# **Aquind Interconnector**

## **Local Impact Statement submitted by**

### **Winchester City Council**

Aquid Countryside Option

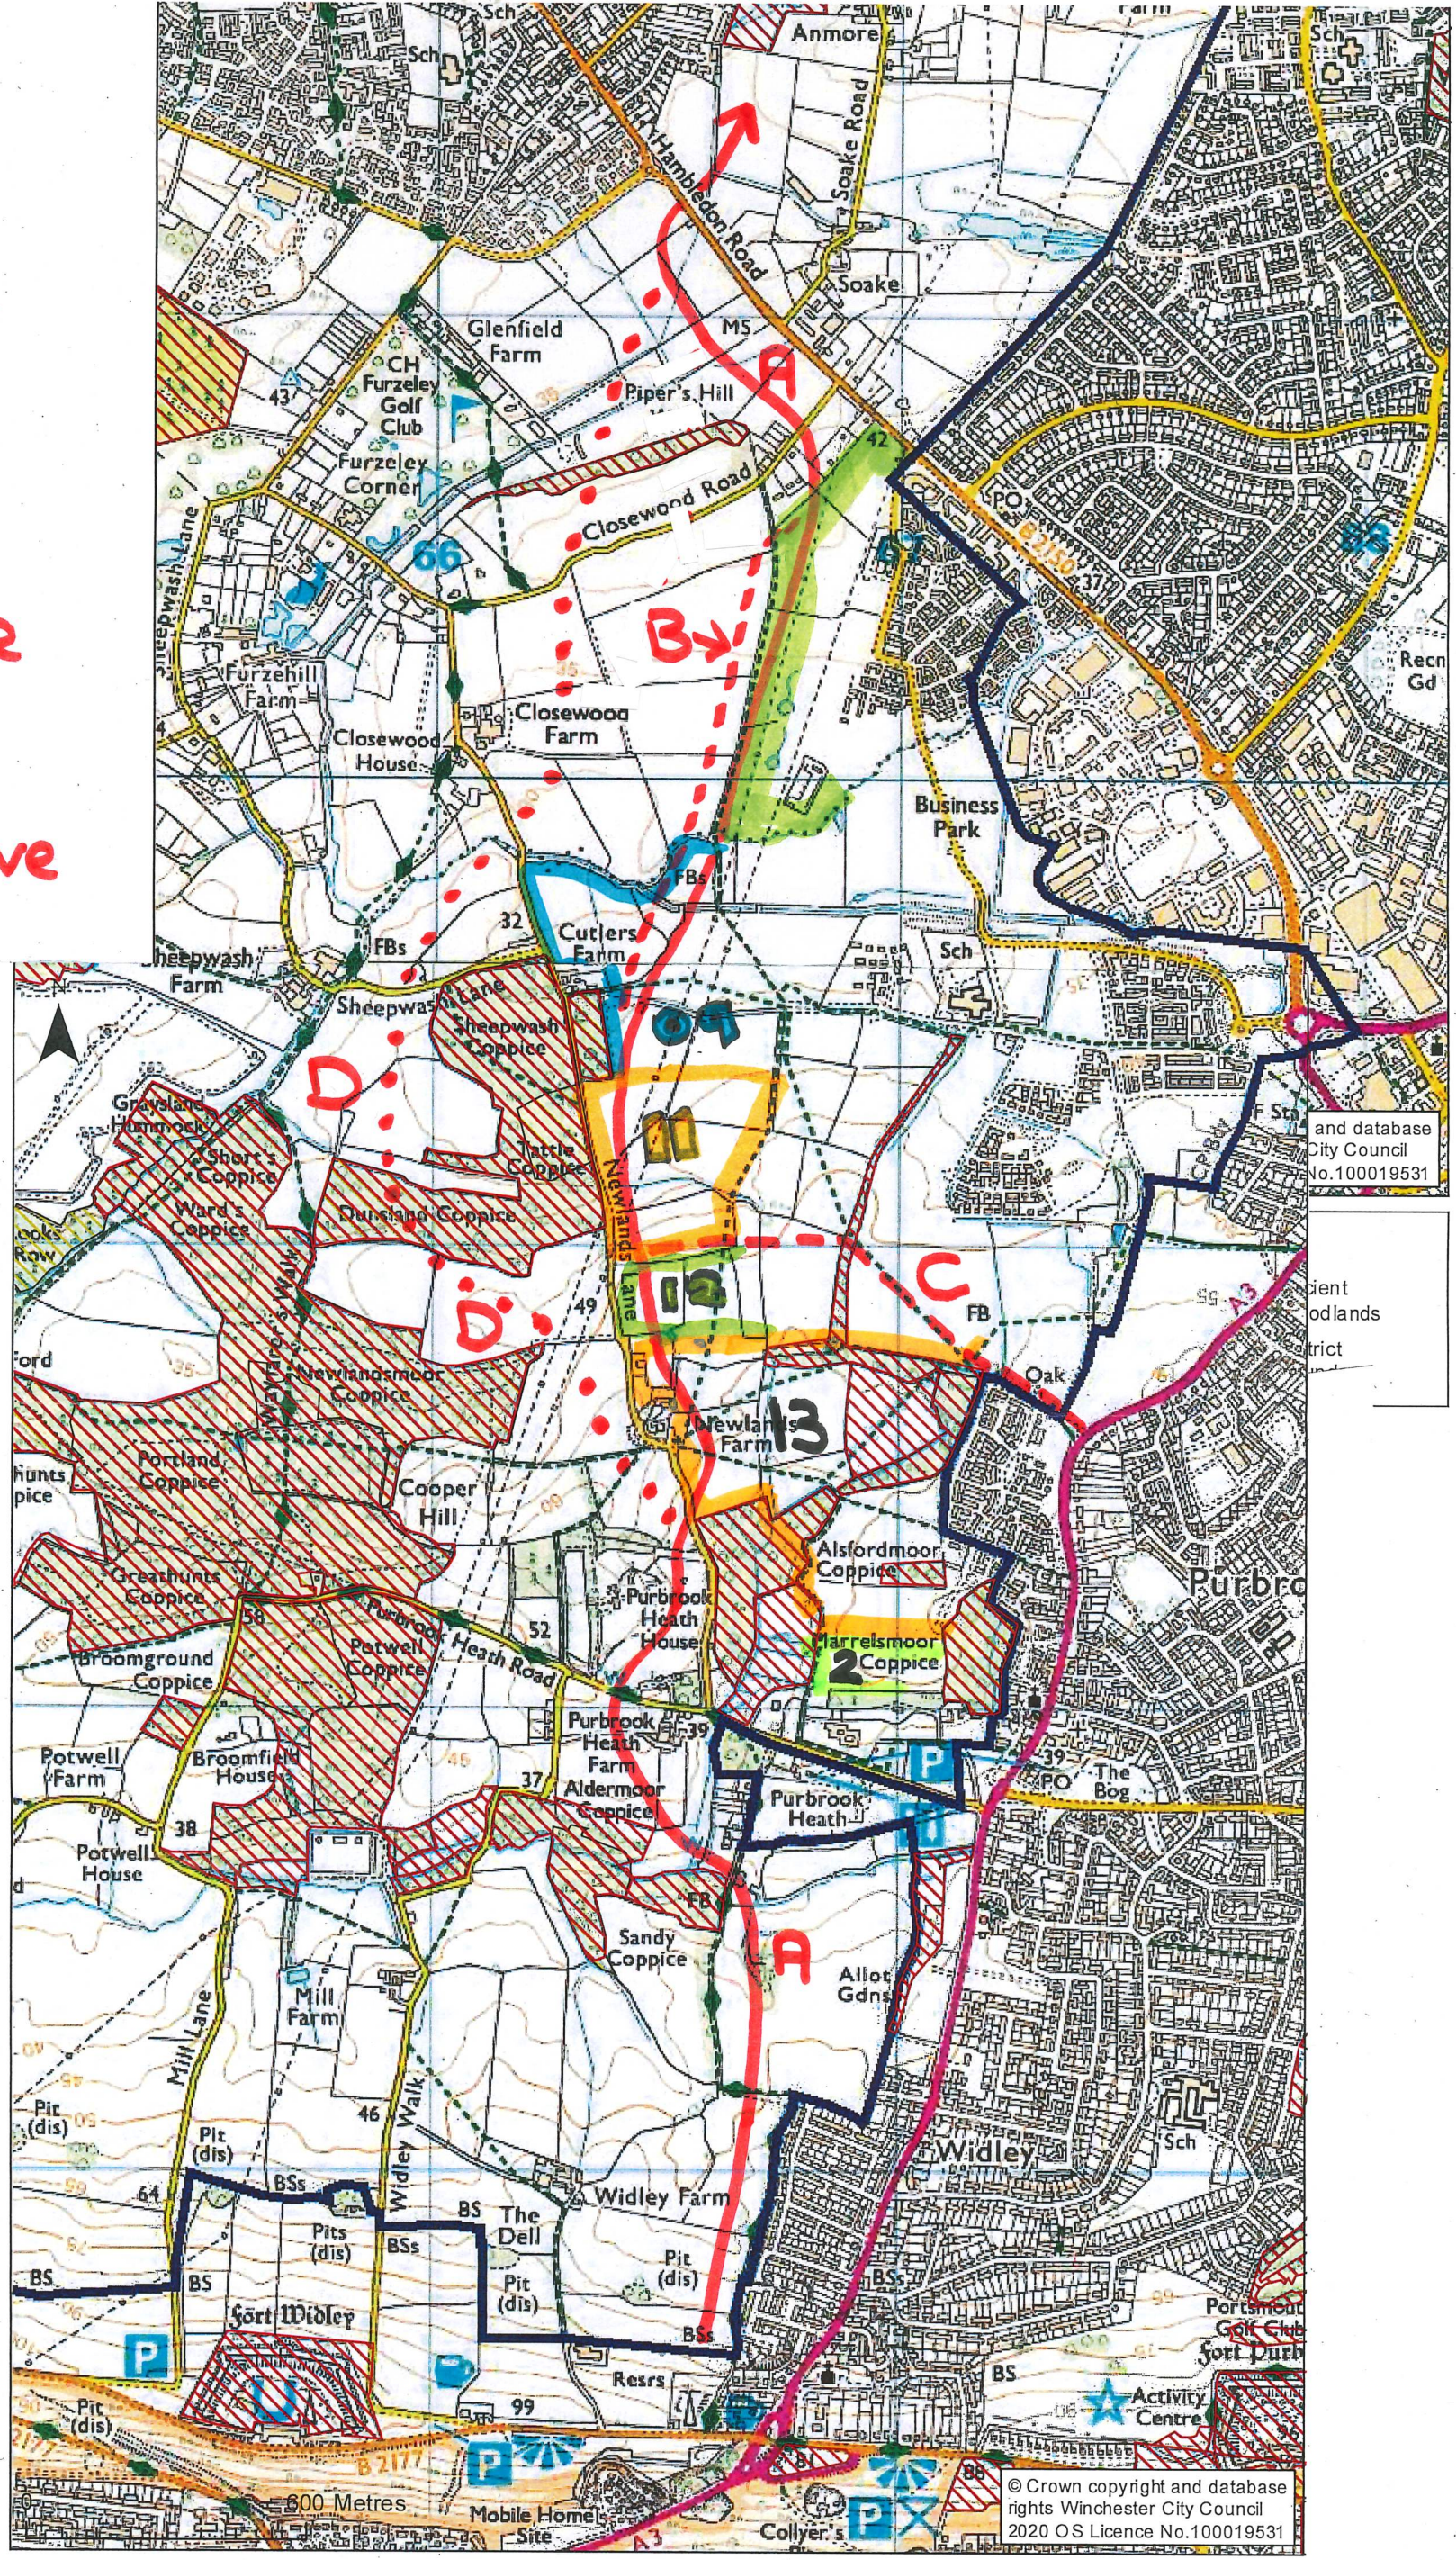
The applicant does not appear to have considered the merits of the countryside route in comparison to the road route. These merits have grown over the past 12 months as concerns over working in the highway have grown. If the countryside option was possible, then such a route would remove all those concerns associated with using the A3 and B2150.
